Recommendation Report for Planning Permission for Works or Extension to a Dwelling

REF NO: FG/52/22/HH

LOCATION: 6 Beehive Lane
Ferring
BN12 5NL

PROPOSAL: Erection of two storey front extension with front canopy, single storey side and rear extension and extension of loft to habitable use including the installation of 1 x side dormer.

Drawing
Proposed Elevations

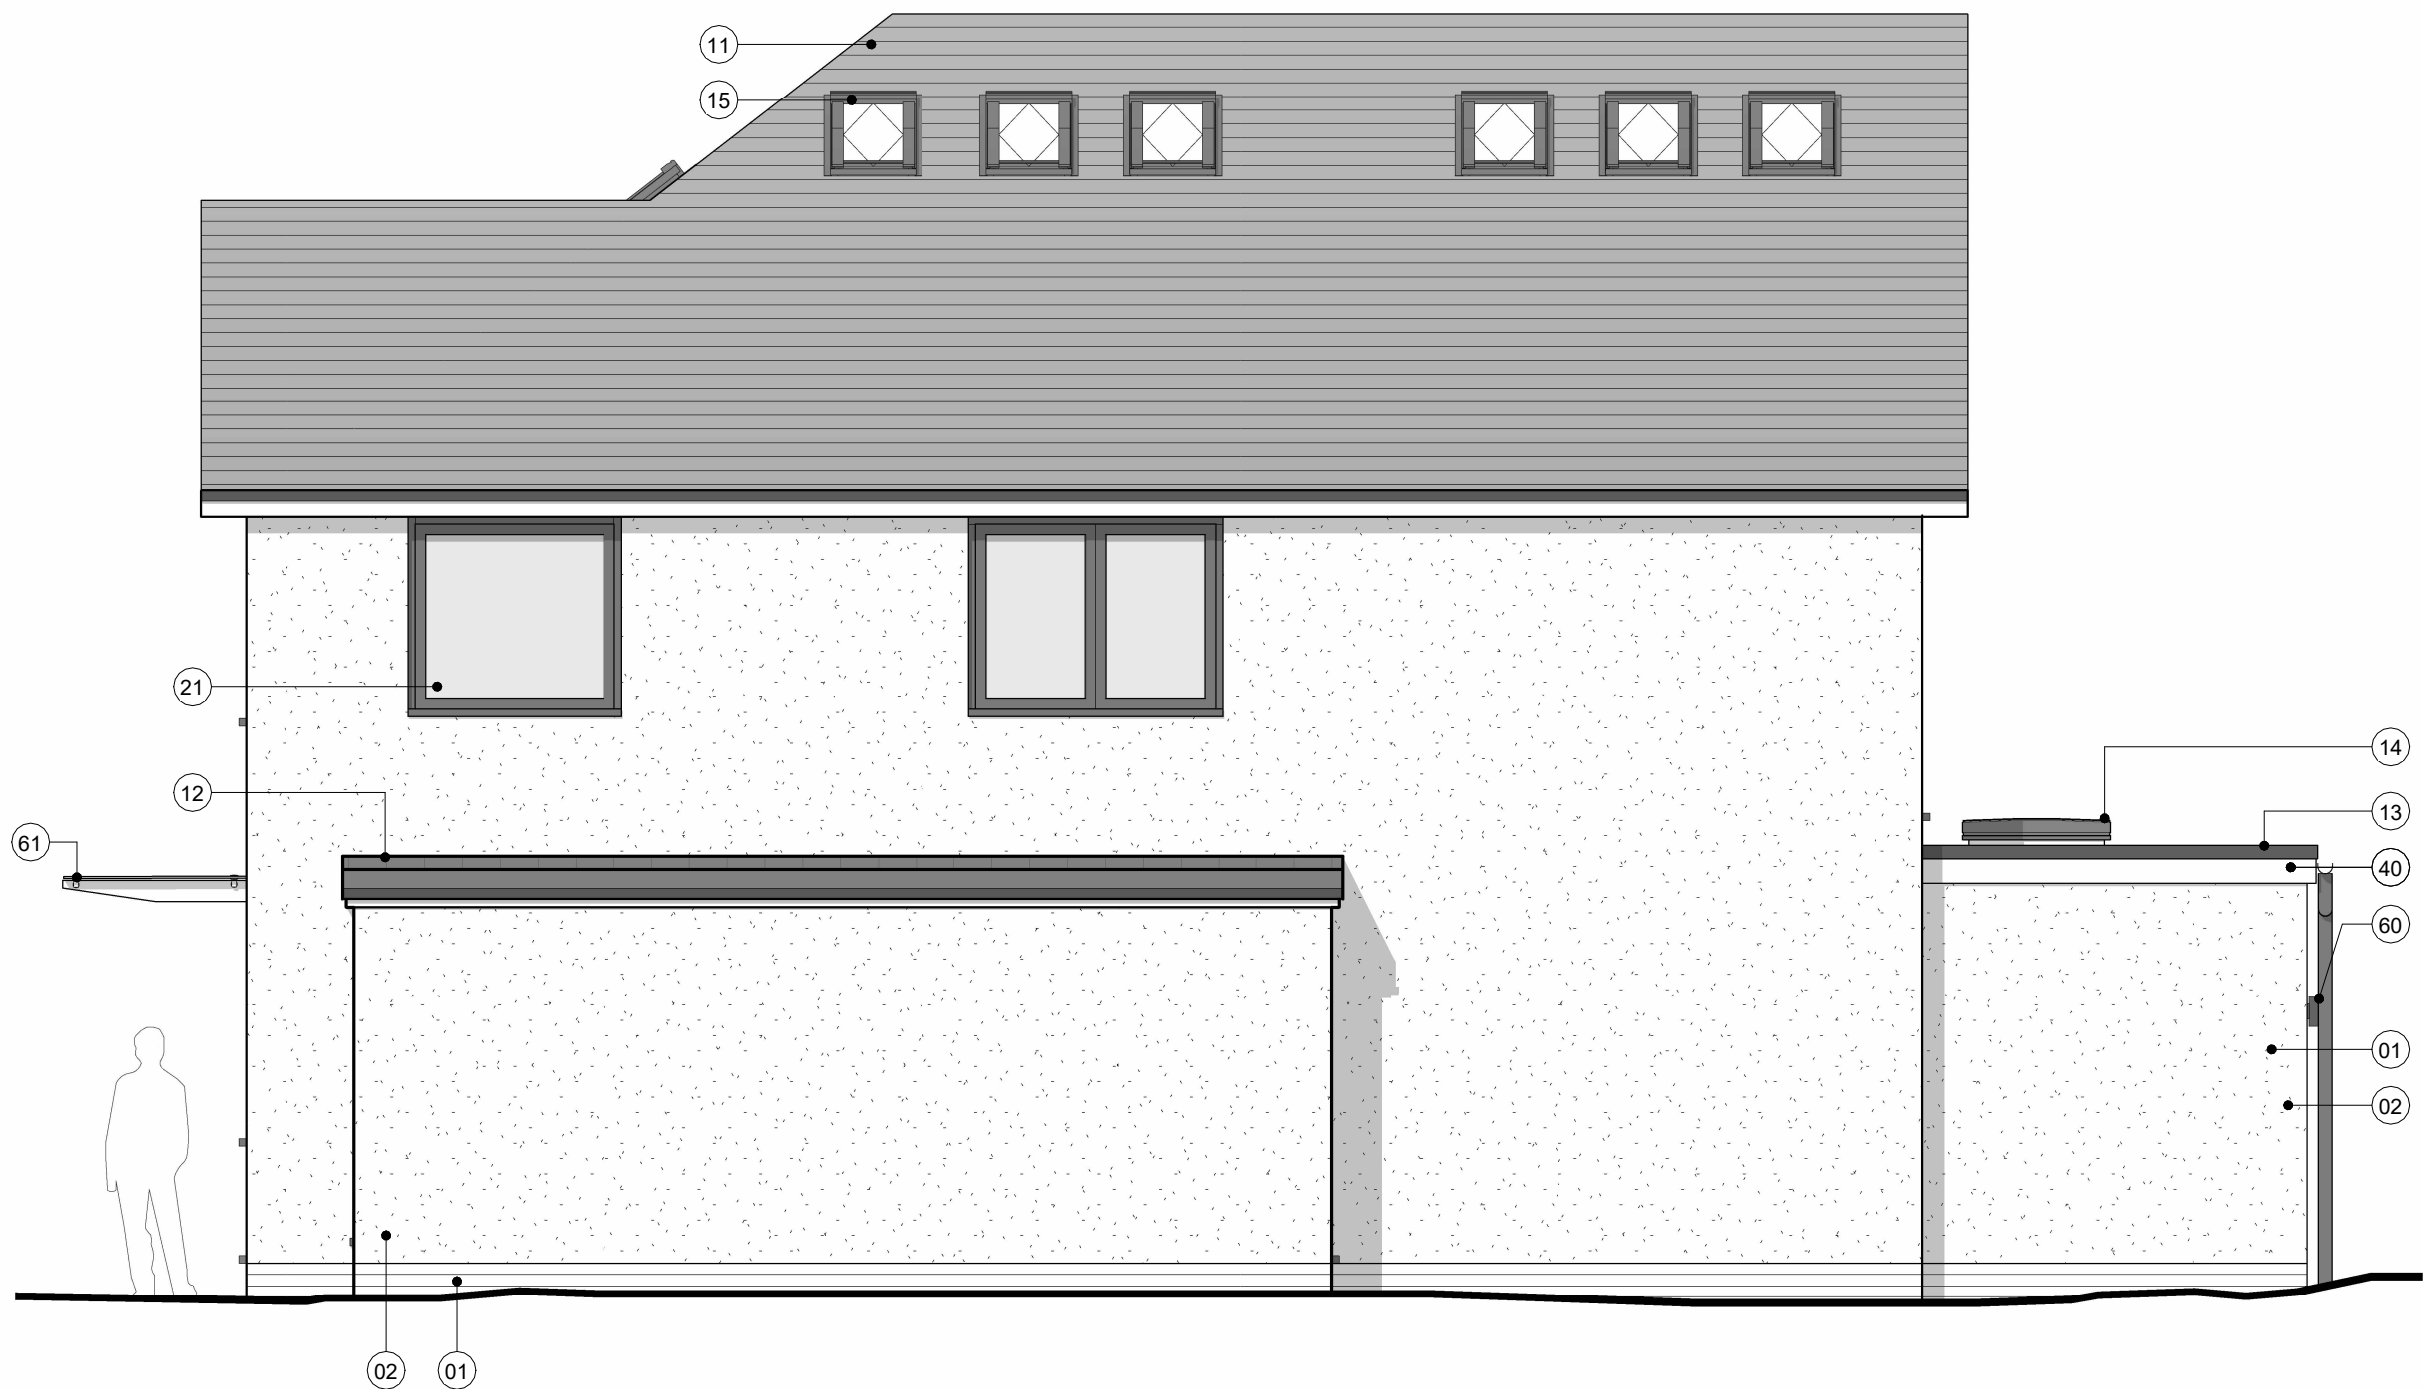
It is proposed to construct a two-storey gabled roofed front/side extension, the extension will measure approx. 2.4m by 4.4m, in filling to the front of the property and will include a roof canopy for an open porch. This extension will extend pass the primary elevation by approx. 200mm. A separate front/side single storey with mono pitched roof extension to the western elevation is also proposed, this will measure approx. 1.5m by 2.5m. Finally, a hip to gable roof extension plus a side facing box dormer is proposed, the hip to gable extension is to the rear of the property and the box dormer will be located to the western elevation. There are also changes to some of the materials to be used in the build, it is proposed to fully render the front and western elevations, removing an existing brick finish to the upper part of the dwelling, to the rear and eastern elevations a fully clad finish is proposed in light oak. The side facing dormer is also to be clad in light oak.

The side extension has a height far lower than the host dwelling and is an extension to an existing side extension, as such it will be a subservient addition to the host dwelling. The proposed box dormer by reason that it has a lower ridge height than that of the host dwelling, its position back from the primary elevation by 3.7m and its retention of the existing eaves line means it will also be subservient to the host dwelling. The two-storey front extension will have the most significant impact on both the street scene and the host dwelling. The design to the frontage will retain key elements of the existing building such as

the bay frontage, eaves line and (although in a different position) a new subservient gable-end protrusion. As such, it will comply with policy in that it will be subservient to the host dwelling. Although new materials are proposed, the new additions are afforded good visual integration by reason that they are consistent and in-keeping with the area which hosts a variety of built materials including weatherboarding.

Comments have been received relating to the box dormer and hip to gable rear extensions being overbearing on the neighbours to the east and south. It is noted that the host dwelling already has rooms within the roof, although only a smaller rear dormer is present. As it currently stands the two-storey property is already significantly larger in height than the bungalow to the east and is incongruent within this grouping of smaller houses. The proposed development will be adjacent to the roof structure of the bungalow and the full effect of the height of the dormer will not be felt by users of the amenity space to the east by reason of this side-to-side relationship. The rear hip to gable extension required to facilitate the dormer will be contained within the confines of the existing buildings footprint so will not overbear neighbouring properties. In terms of overshadowing the increase in ridge will have some effects of overshadowing but this will be predominantly to the roof of No 8 (east) in the late afternoon and to the side elevation/roof of 4A (west) in the morning, given most of the structure is already existing this will already occur to some extent. Although there will be an impact from overbearing and overshadowing, it will not cause significant harm.

Comments have also been received regarding concerns for privacy through overlooking. No new views which are not already achievable will be created from any of the proposed fenestration located on the northern or western elevations. The roof lights to the western elevation appear to be above 1.7m from finished floor level, other windows face the public realm. The windows to the east are described within plans as obscure glazed, all other windows above ground floor levels are as existing. The glazed gable to the southern elevation has a direct back-to-back relationship with No 4 Chalet Close. The glazing at first floor level to the southern elevation will be lessening and will therefore improve the situation however, new glazing will be introduced at second floor level. This glazing replaces a much smaller rear gable which is set back by over 1.5m from the rear line of the elevation, by moving the glazing forward the 1.5m only 19m is retained between the two facing elevations, without control this would provide an unacceptable form of development. This window along with the other side windows/veluxes mentioned above will be conditioned to be non-opening and obscure glazed, to protect the privacy of all surrounding neighbours.

- Location and Block Plans 1002
 - Proposed Plans 2002 02
 - Proposed Elevations 2003 02
Reason: For the avoidance of doubt and in the interests of amenity and the environment in accordance with policy D DM1 of the Arun Local Plan.
- 3 The second floor rooflights/windows hereby approved to the western, eastern and southern elevations shall be non-opening and fully obscured windows below 1.7m from finished floor

level prior to the first use of the rooms. The windows shall be retained as obscure glazed/non-openable in perpetuity.

The first floor window to the western elevation serving Bedroom 2 shall be a non-opening and fully obscured window below 1.7m from finished floor level prior to the first use of the rooms. The window shall be retained as obscure glazed/non-openable in perpetuity.
